DEVELOPMENT REVIEW BOARD
TRANSPORTATION DEVELOPMENT

DRB Project Number: 1001523
Ladera Business Park-
Las Lomitas Plaza

SUBJECT: Site Plan for Building Permit

Project Name: Las Lomas Plaza (Ladera Business Park)

SHEET: A001
 Sheet 1 of 9

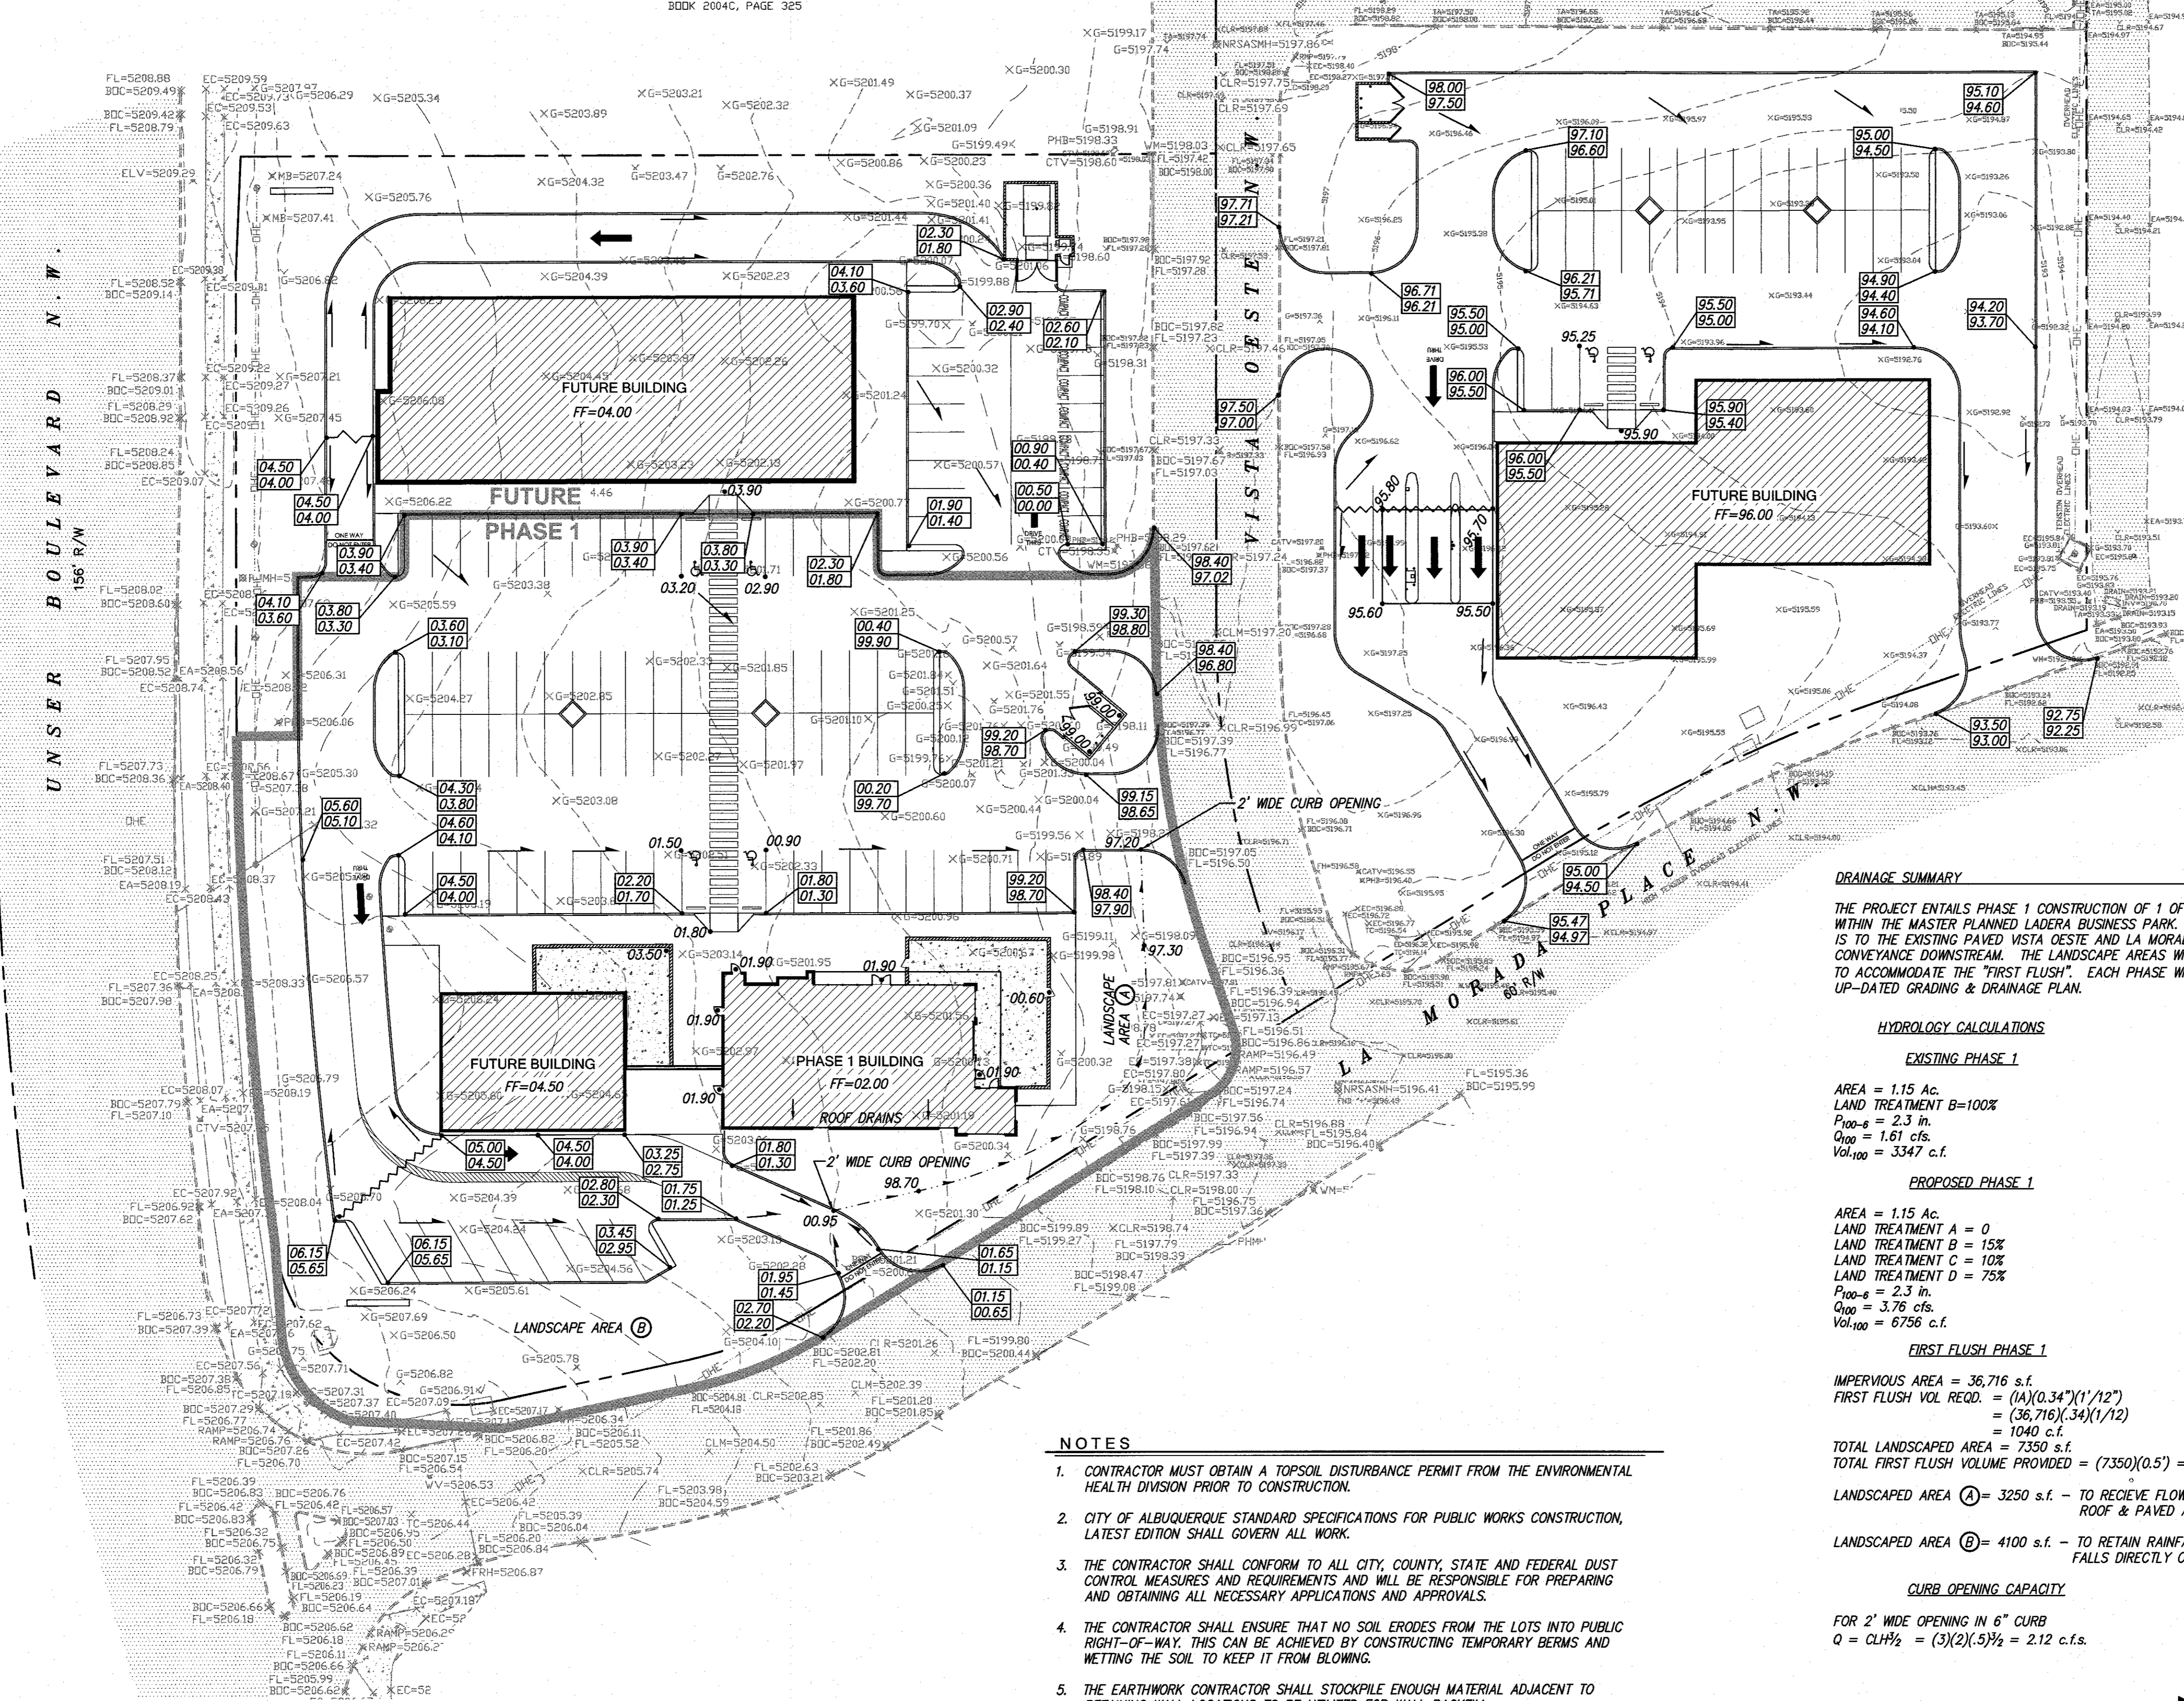
1. Site lighting notes are on Sheet 1 in two locations, so one can be removed.
2. Note: the Site Plan for Subdivision (SPS) includes a very specific light fixture type to be used in this development.

3. Minor typos/inconsistencies in the lot area and allowed FAR in the FAR calculation.
4. Clear sight triangle keynotes are in multiple locations but the triangle is only visibly shown in one. Defer to Transportation for requirements.

5. Keynote #23 indicates shading for Phase I work, but no shading is apparent.
6. The signature block used includes language for EPC cases that can be removed.
